The British Horse Society

10th December 2024

RE: Application by EPL 001 Limited for an Order Granting Development Consent for Stonestreet Green Solar

Drawing Title:
 Traffic Regulations
 Measures Plan
 Sheet 1 of 7

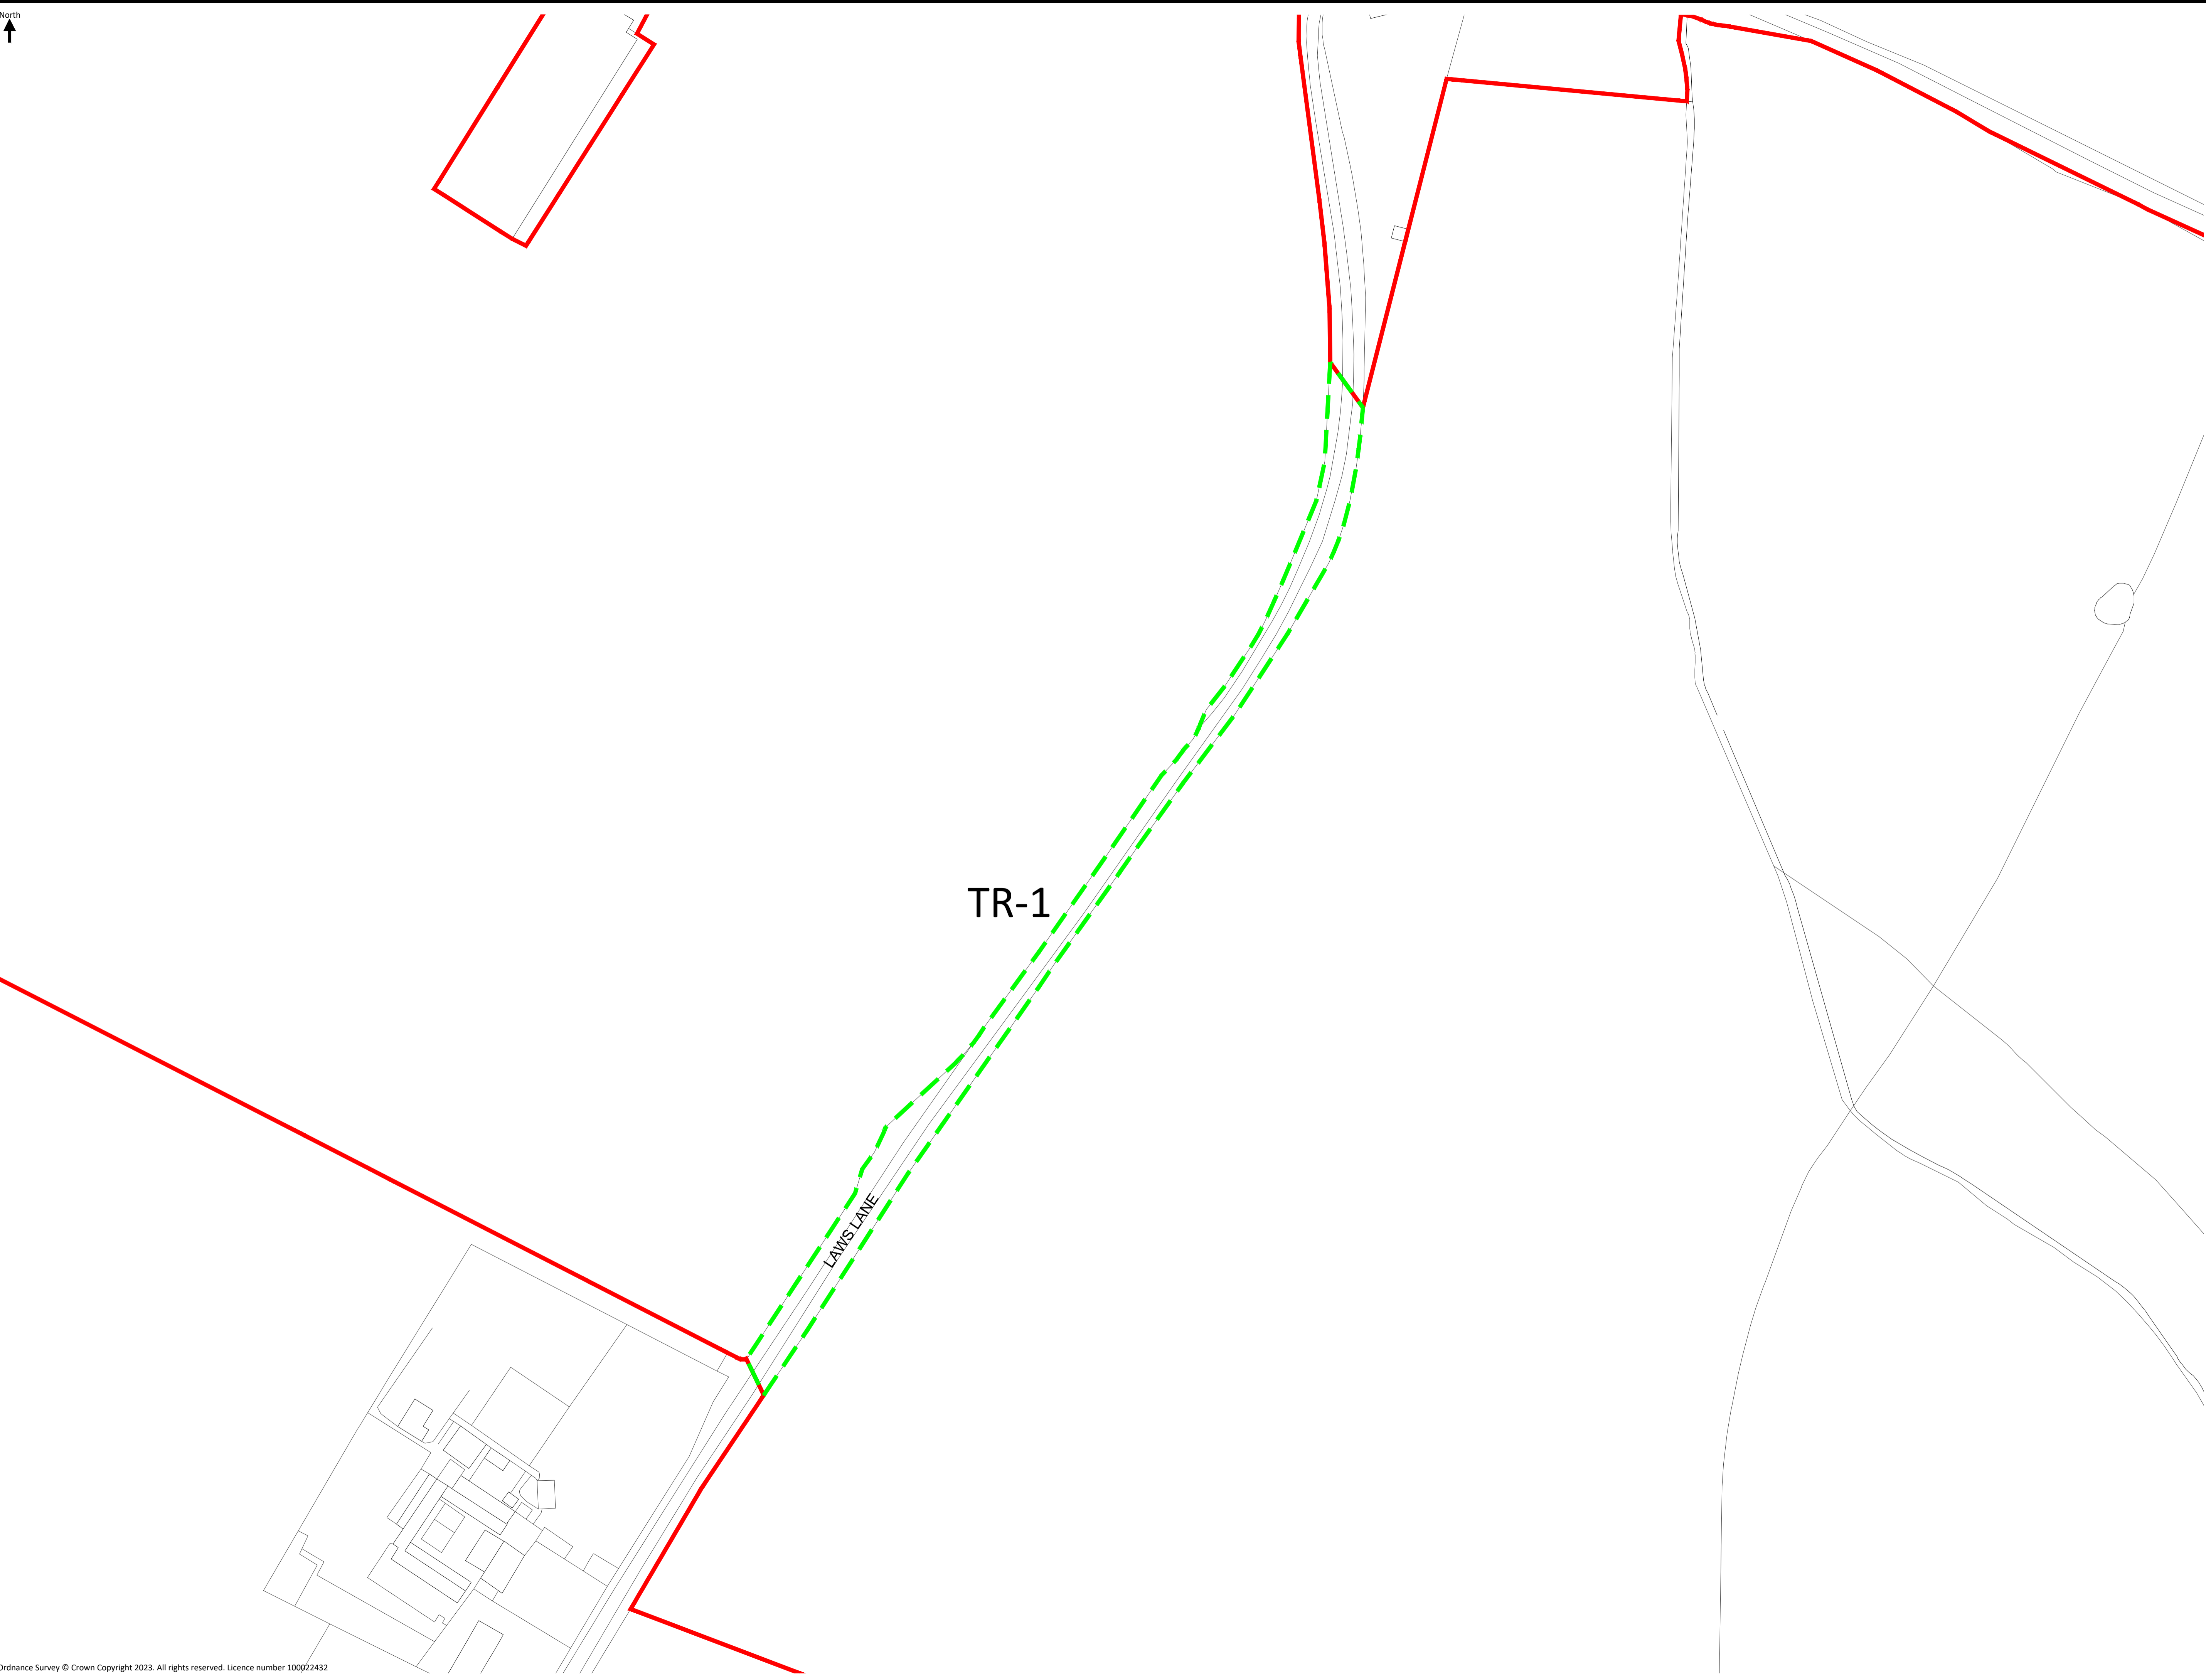
Further, Laws Lane appears to be similarly impacted. Laws Lane is currently a quiet country lane forming part of a hacking route popular with riders, often used in conjunction with Bank Road, byway AE396 and Frith Road to form a circular route. This will also be seriously impacted by crossing construction vehicles and displaced traffic from Aldington heading to the A20, further degrading the amenity of horse users .

Drawing Title:
Traffic Regulations
Measures Plan
Sheet 2 of 7

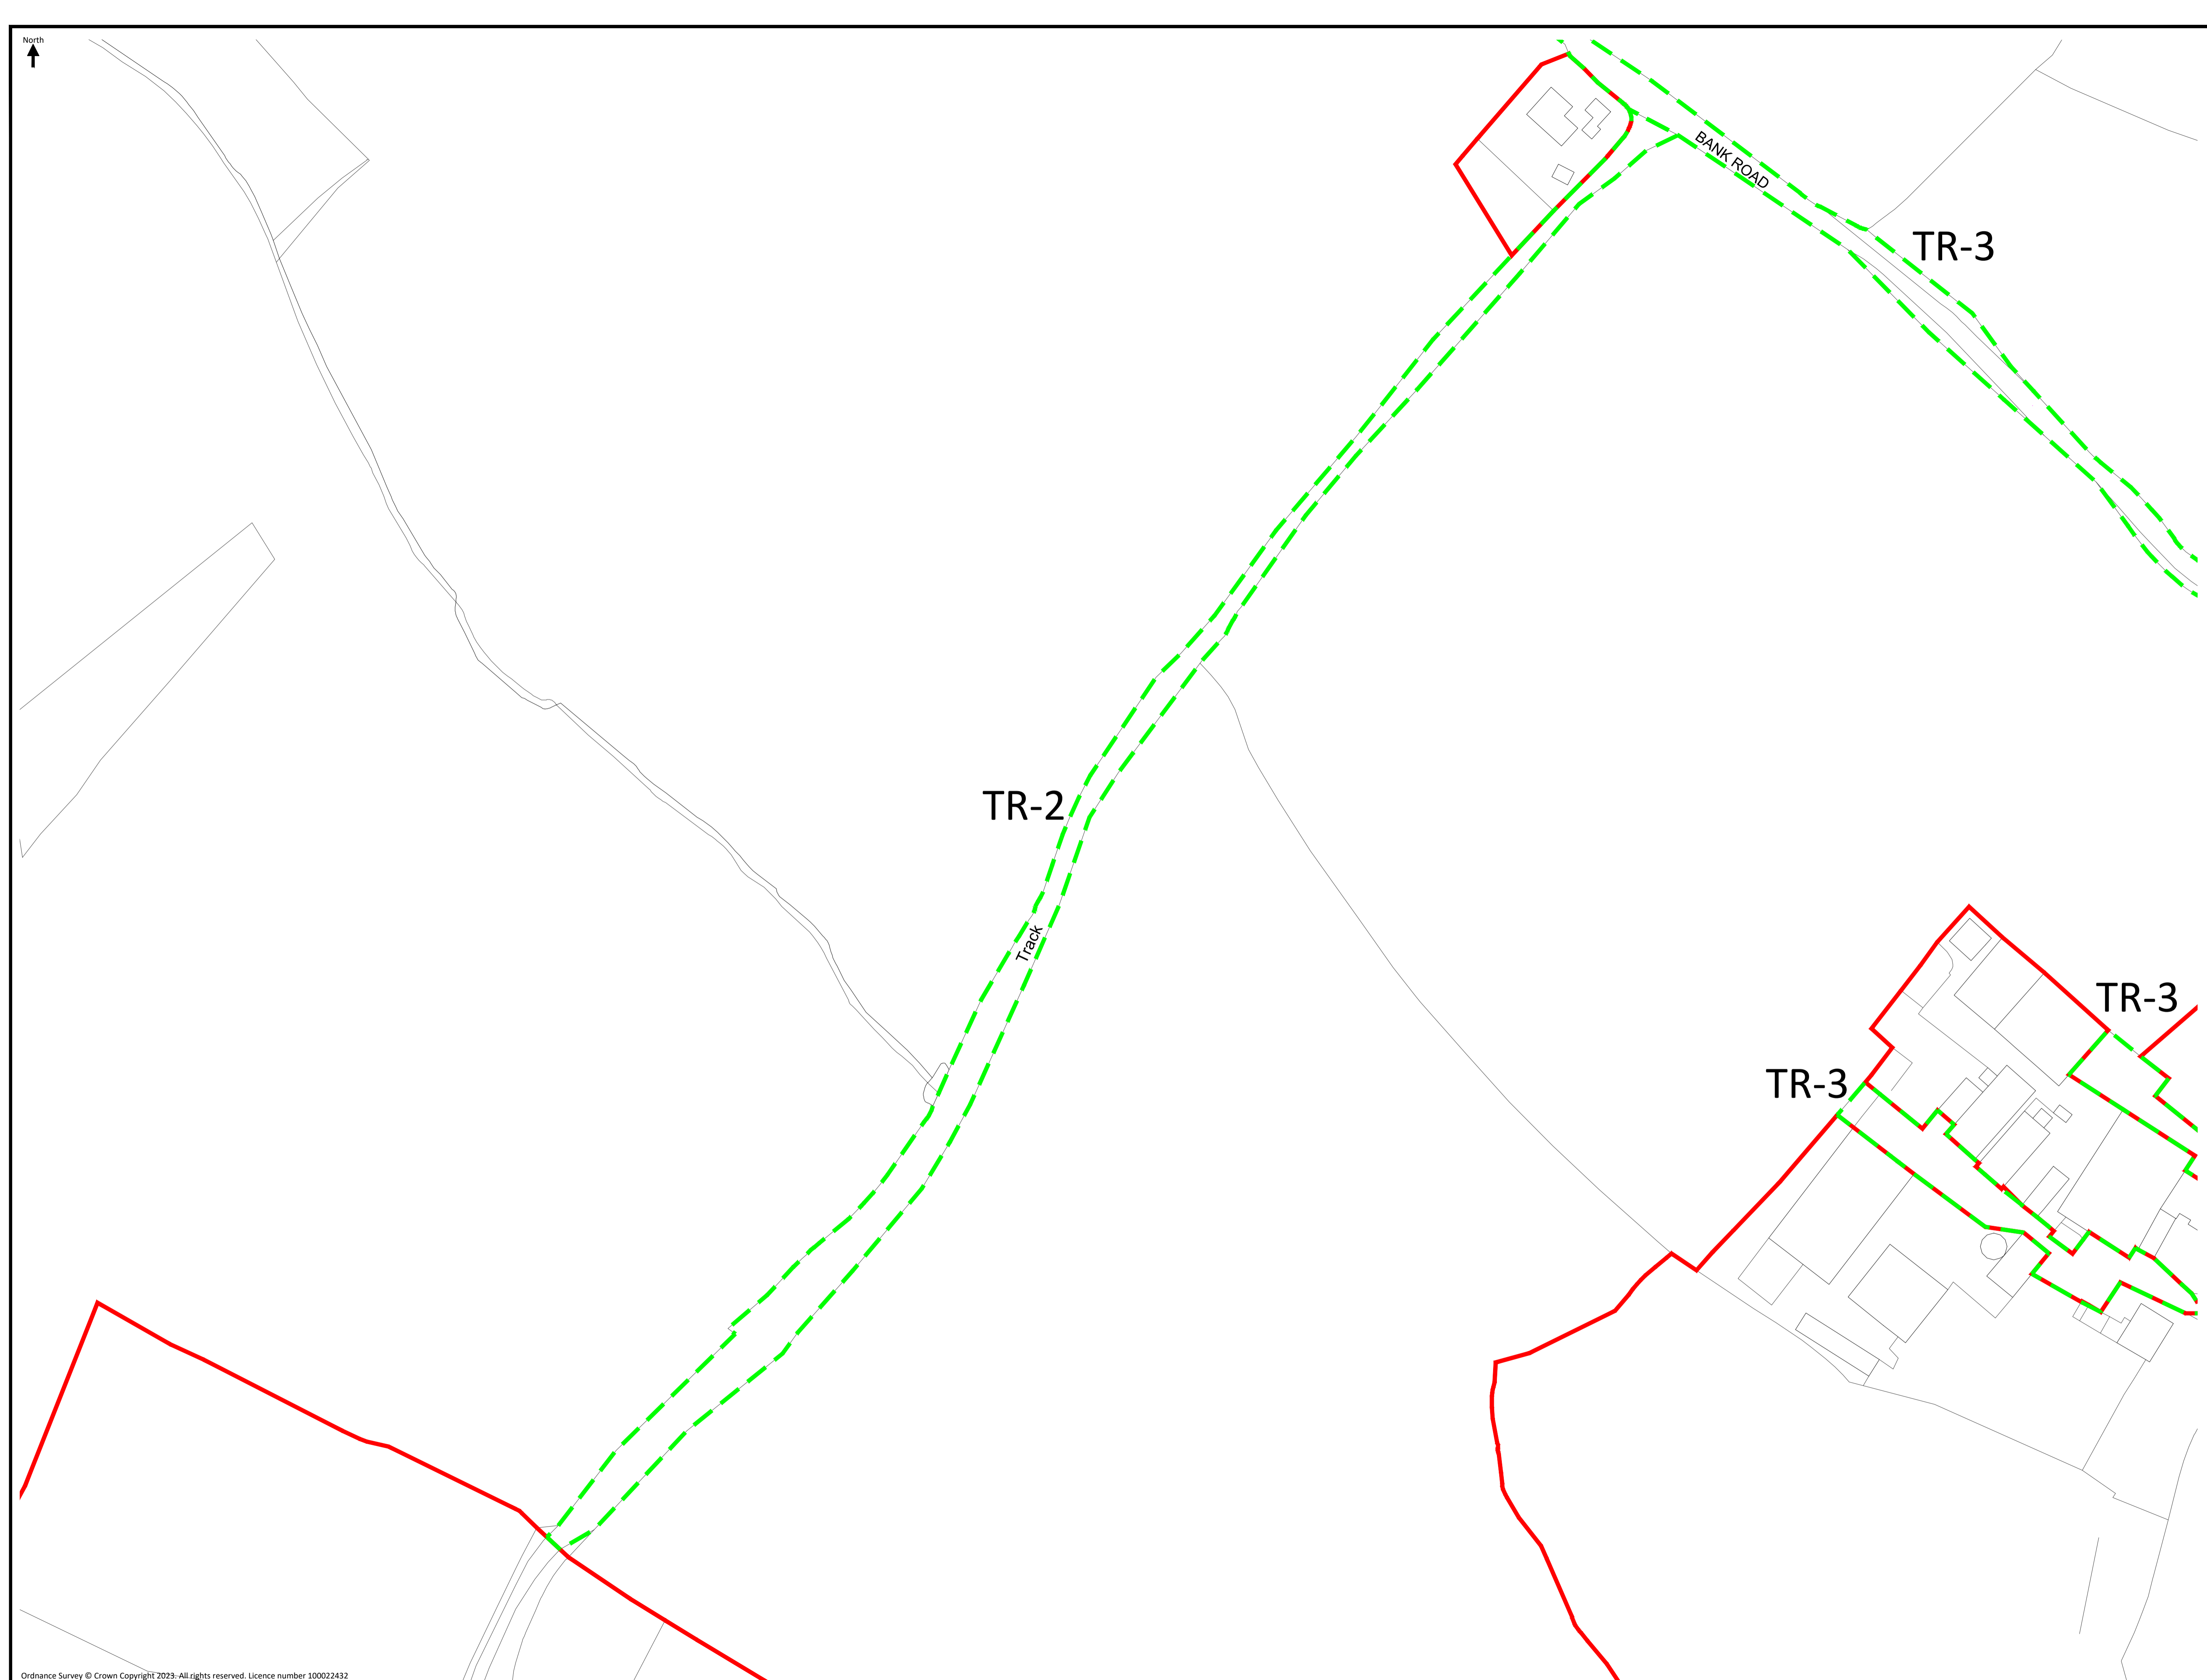
On the SSG Construction Traffic Routing and crossing plan (Figure A1) byway AE396 is shown as having **three** crossing points identified (we believe one, and certainly no more than two, should suffice). I understand that it is proposed that the public will be made aware of crossing traffic by lights and noise. This is not appropriate close to a public highway used primarily by walkers and horse riders. If these routes are to be crossed by construction traffic, the banksman in place should stop the construction traffic while the PROW user continues with their journey. Following construction, traversing of the byway by site traffic needs to be strictly controlled in such a way as to ensure the byway surface is not affected adversely and nor is user safety. The byway should not be surfaced with a sealed surface as this would invite increased use by even more vehicular traffic.
